Response to Engineering Items in An Bord Pleanála's Pre-Application Consultation Opinion

Residential Development at Broomfield SHD Lands, Malahide

March 2022

Client: Birchwell Developments Ltd.
Document Reference: 18-091r.011 Response to An Bord Pleanála's Pre-Application Consultation Opinion
Project Number: 18-091

DRAWN PJD	DESIGNED RW	APPROVED MD	DATE NOV '20
SCALE 1:2000 @ A1	JOB NO. 18-091	DRG. NO. P100	REVISION A

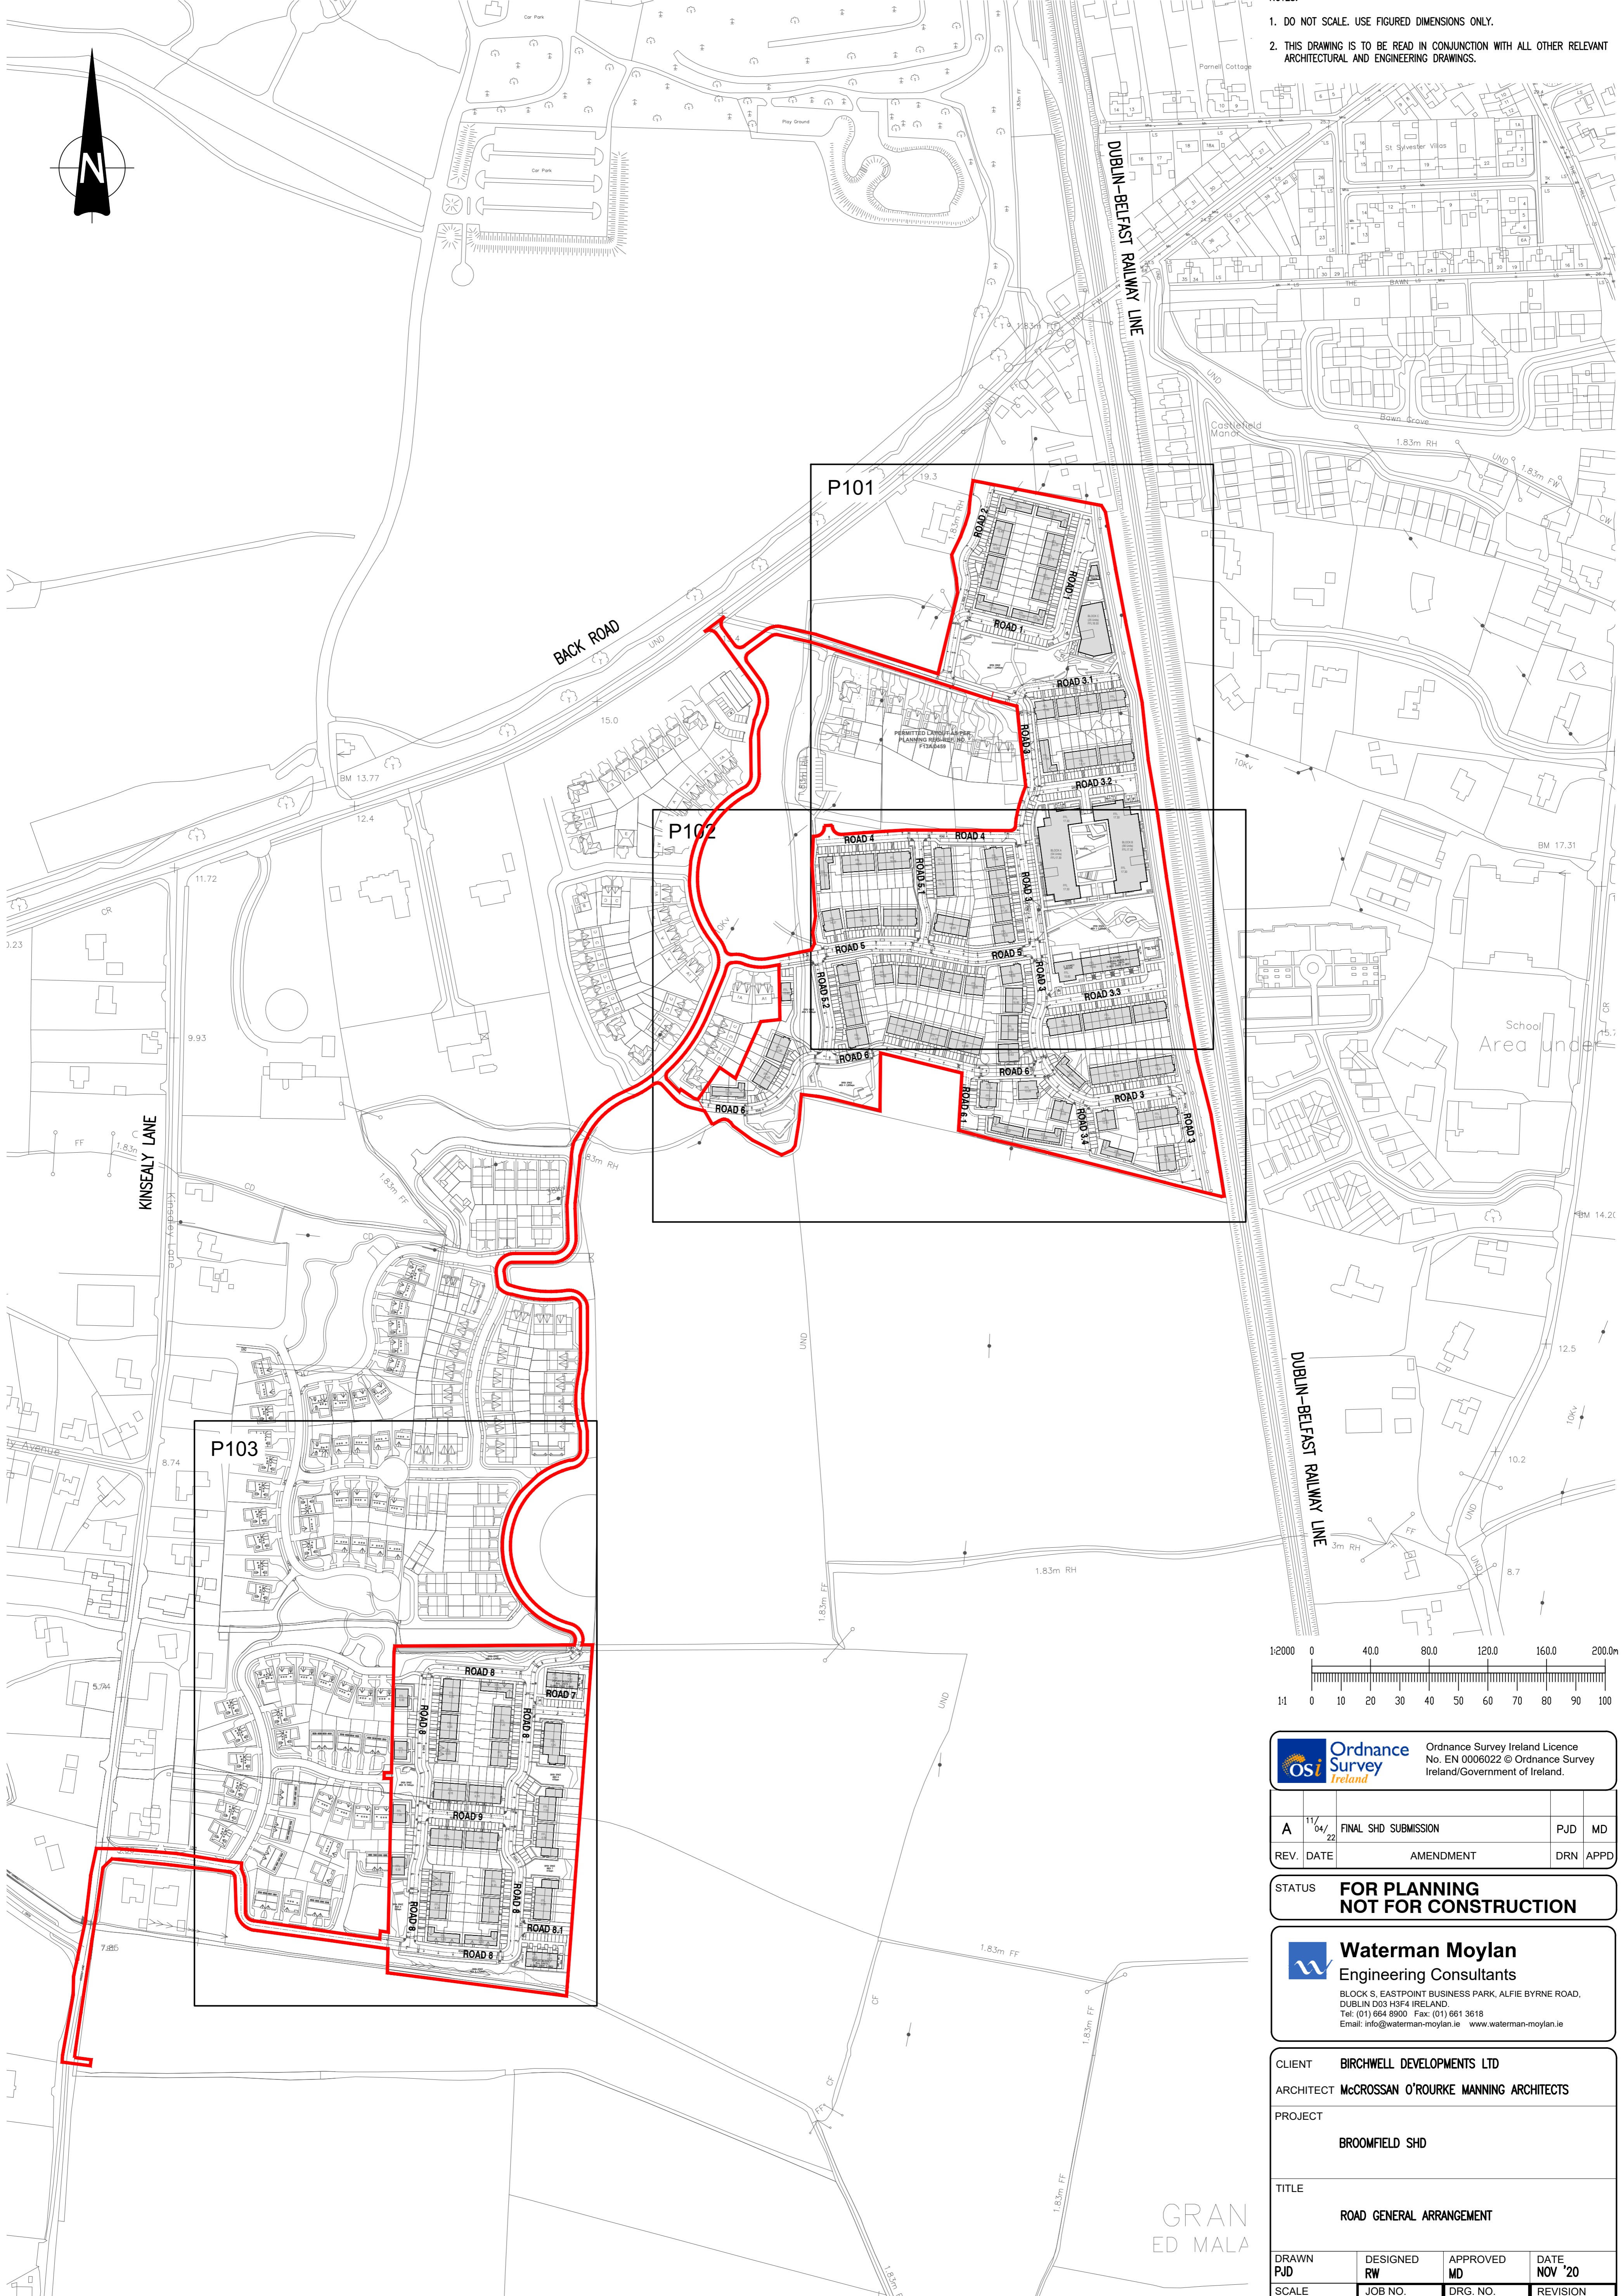
Further consideration and elaboration of the documents as they relate to the design and layout of internal streets, specifically the design of the proposed home zones, car and bicycle parking, and positioning of footpaths relative to parking spaces.

All footpaths have been adjusted to ensure adequate space for reverse movement, allowing 11m in total for the parking pace and reverse area. Please refer to drawings P100 to P103.
